**KIRKLEES METROPOLITAN COUNCIL
INVESTMENT & REGENERATION SERVICE**

**DELEGATED DECISION TO DETERMINE APPLICATIONS FOR
CONSENT, AGREEMENT OR APPROVAL REQUIRED BY CONDITION**

Reference No:	2026/44/90555/W
Site Address:	Land off, Woodhead Road, Brockholes, Holmfirth
Description:	Discharge of details reserved by conditions 13 (retaining walls), 15 (retaining walls (materials)), and 17 (surface water features in the Highway) on previous permission 2021/92206 for erection of 137 homes with open space, landscaping and associated infrastructure
Recommending Officer:	Louise Bearcroft

DECISION – Discharge of Condition – Issue Split Decision

TITLE HIGHWAY BURR WALLS
DETAILS ADJACENT TO
PLOTS 8, 9 & 36/37

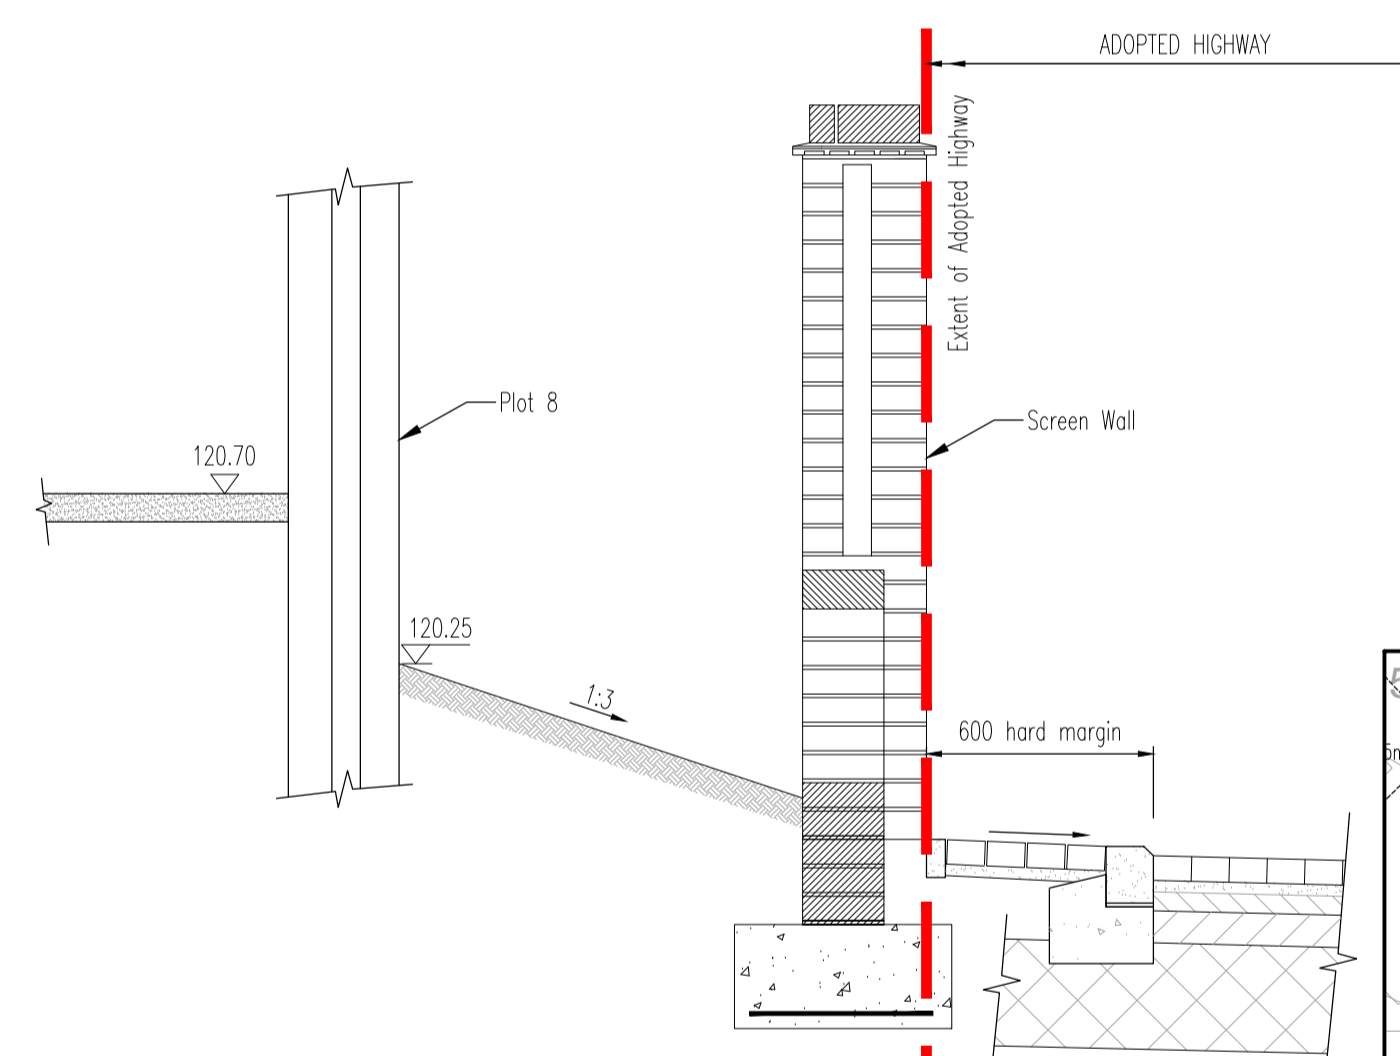
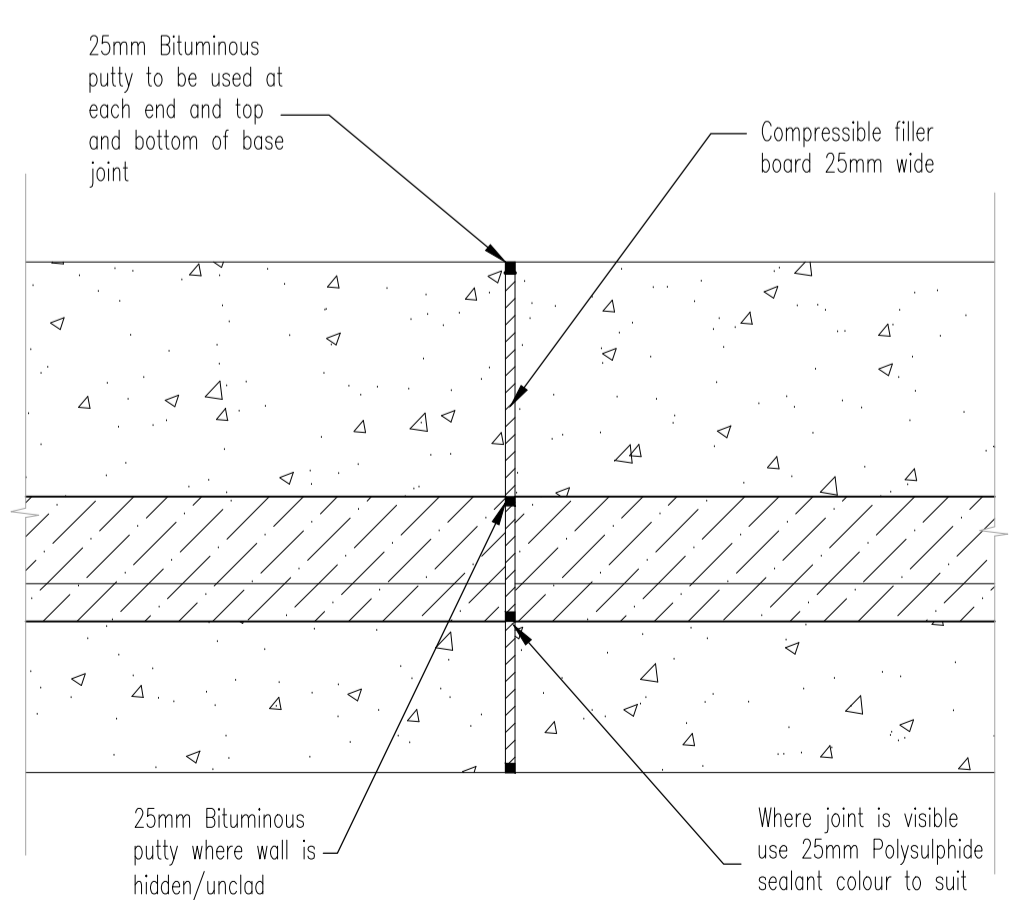
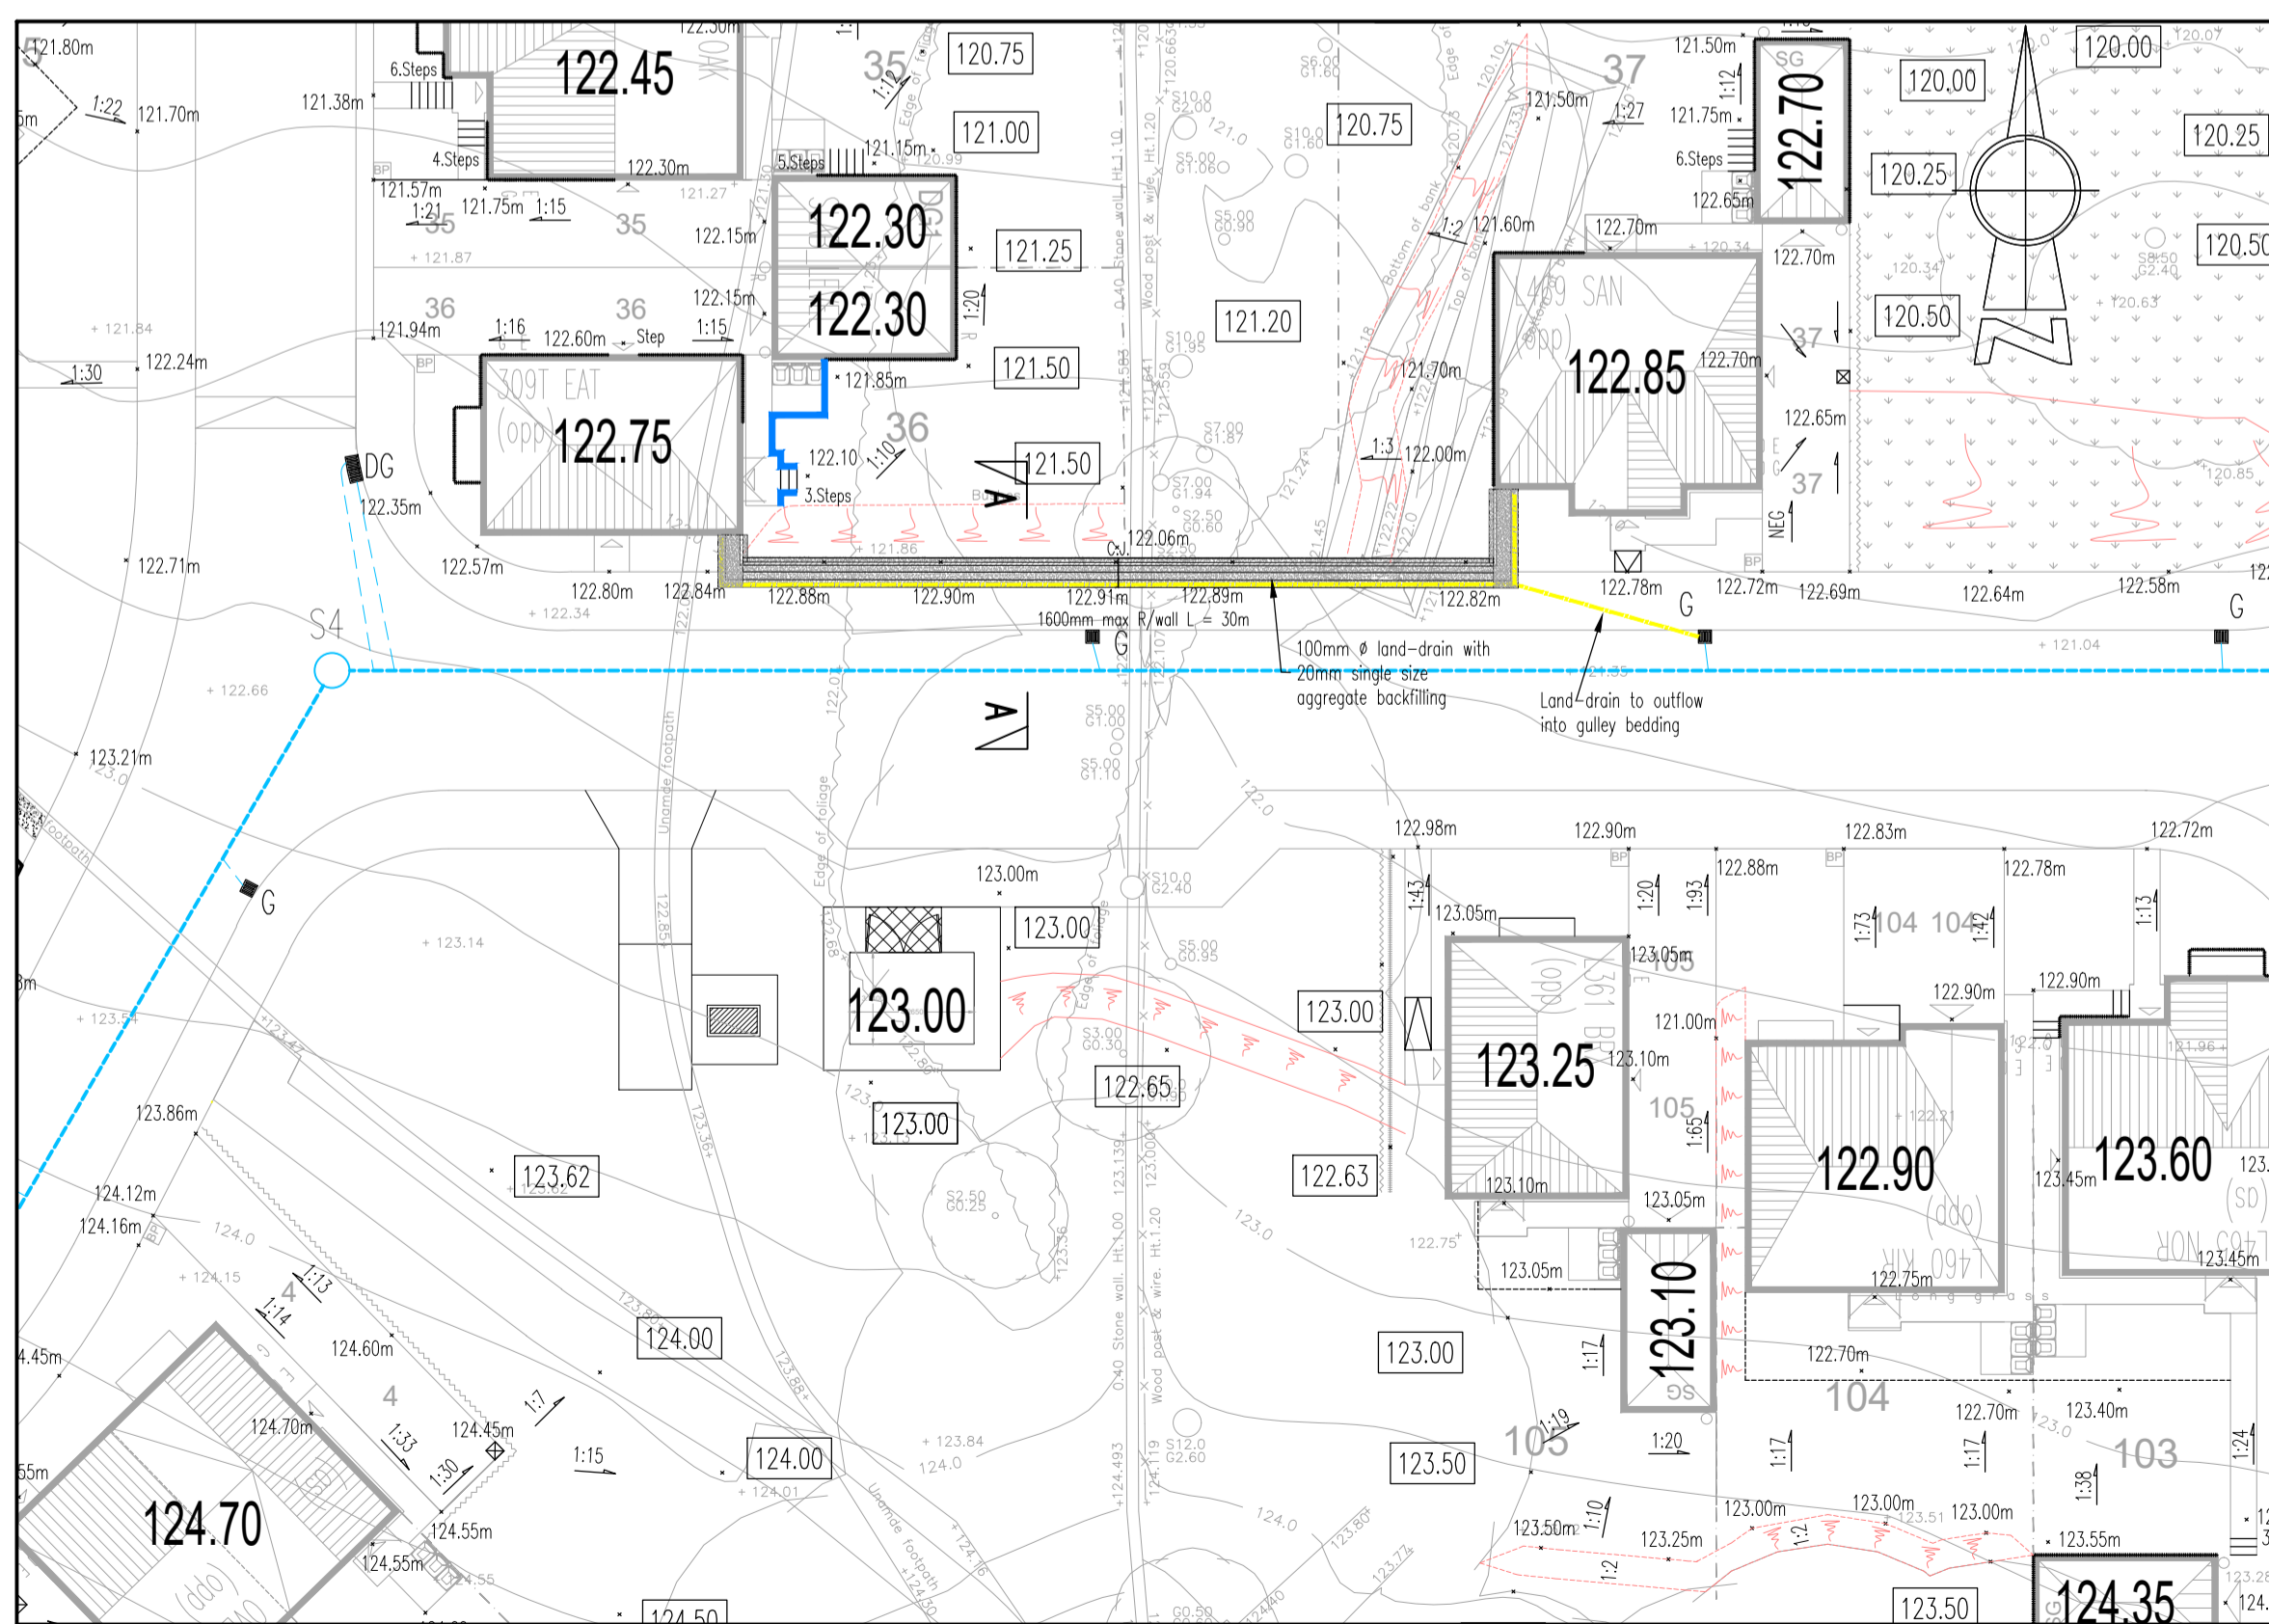
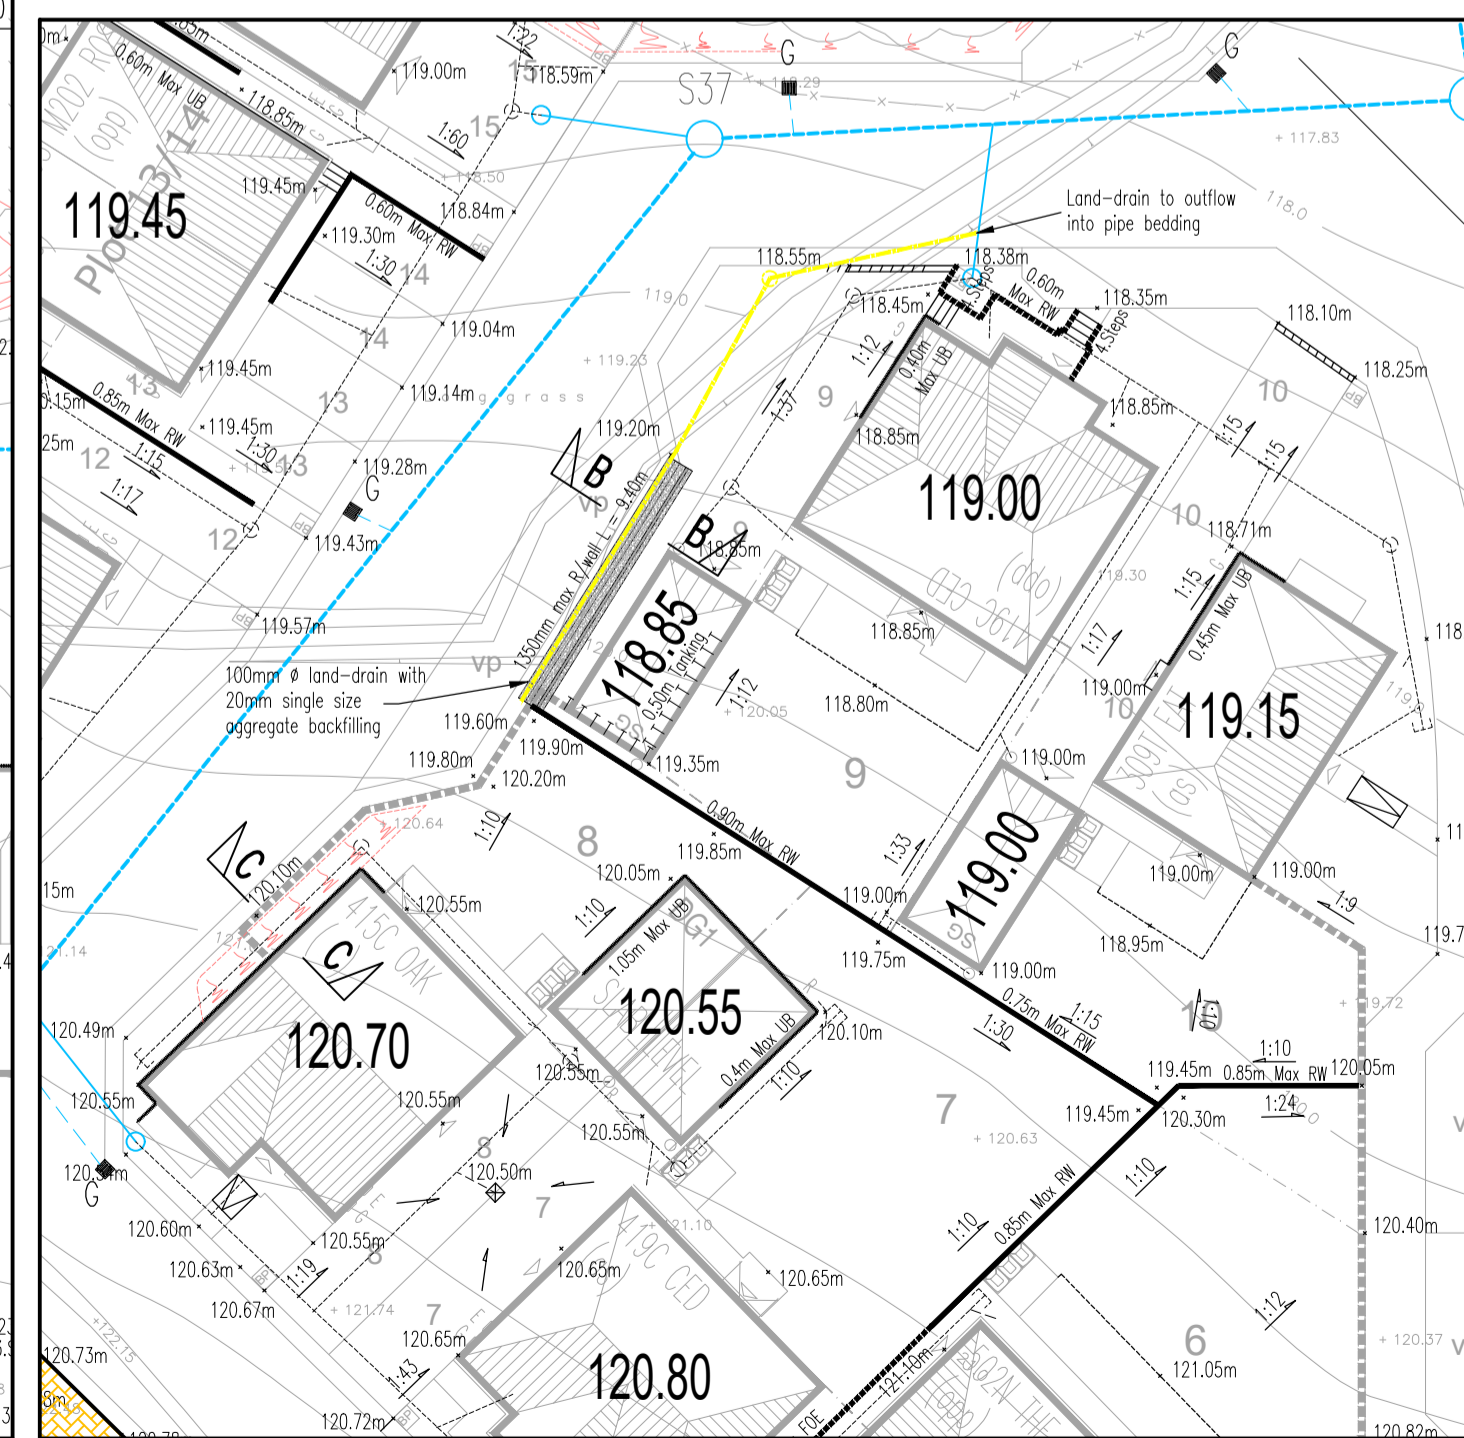
This condition cannot be discharged pending the satisfactory resolution of some outstanding queries including additional ground investigation required to corroborate key assumptions made in relation to the design of new burr wall supporting the access road to the site (see attached e-mail for further details).

K.C Highway Structures note that a satisfactory resolution of outstanding matters including, additional ground investigation to corroborate key assumptions made in relation to the design of new burr wall supporting the access road to the site is first required before the condition can be discharged. Accordingly, in accordance with the comments from K.C Highways Structures, officers cannot recommend that the submitted details be approved and discharged at this time.

K.C Highway Structures require a satisfactory resolution of outstanding matters, including the need for additional ground investigation to corroborate key assumptions made in relation to the design of new burr wall supporting the access road to the site. Therefore, the details are not considered satisfactory for the purposes of satisfying Condition 13.
